# Schedule of Amendments to DCO and Plans

## River Humber Gas Pipeline Replacement Project

**NATIONAL GRID GAS PLC – RIVER HUMBER GAS PIPELINE REPLACEMENT PROJECT  
PINS REFERENCE: EN060004**

**SCHEDULE OF AMENDMENTS TO THE DRAFT DEVELOPMENT CONSENT ORDER AND PLANS  
DOC REF 8.5E**

RIVER HUMBER GAS PIPELINE REPLACEMENT PROJECT		
INDICATIVE PAULL SITE LAYOUT FIGURE 2.4 B		
REFERENCE		
DRAWN	CHECKED	APPROVED
JN	KB	NH
SCALE	ORIG SIZE	SHEET
1 : 1000	A1	1 of 1
DATE		REVISION
12 OCT 15		03

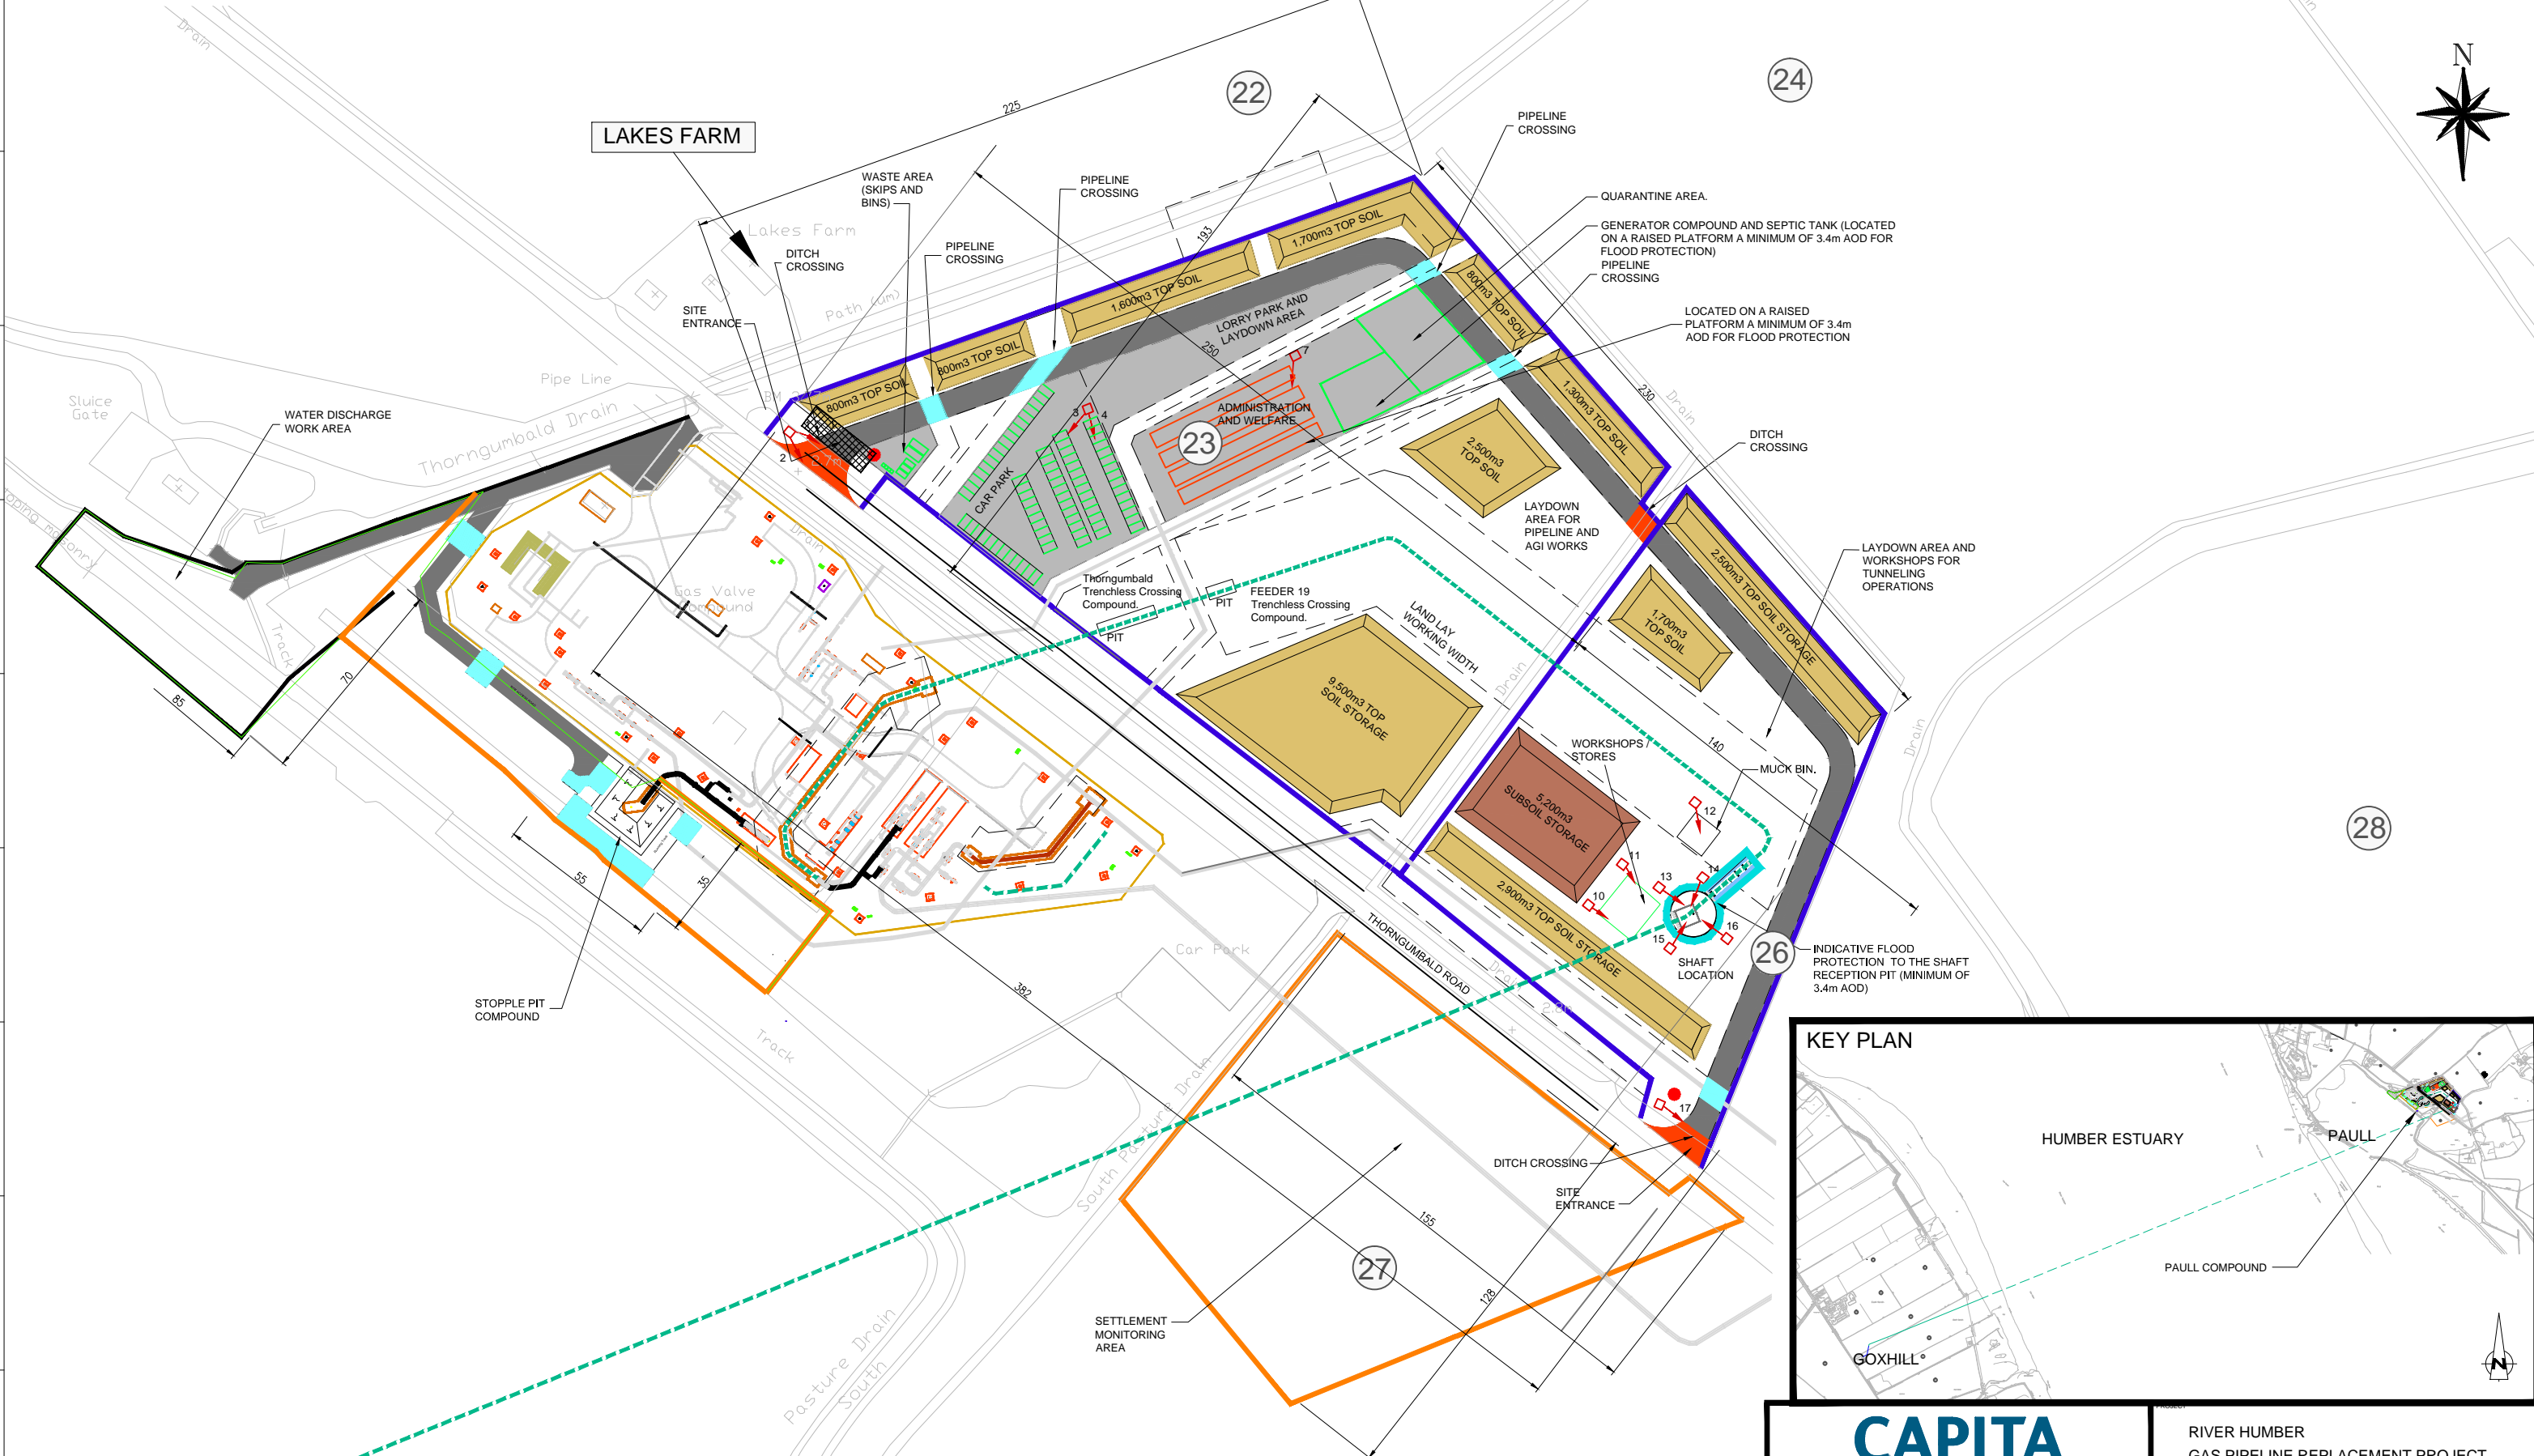
23.09.15	Paull	Location and height of the flood protection to the receive shaft added	In response to request of Examining Authority in Rule 6 letter dated 22 July 2015
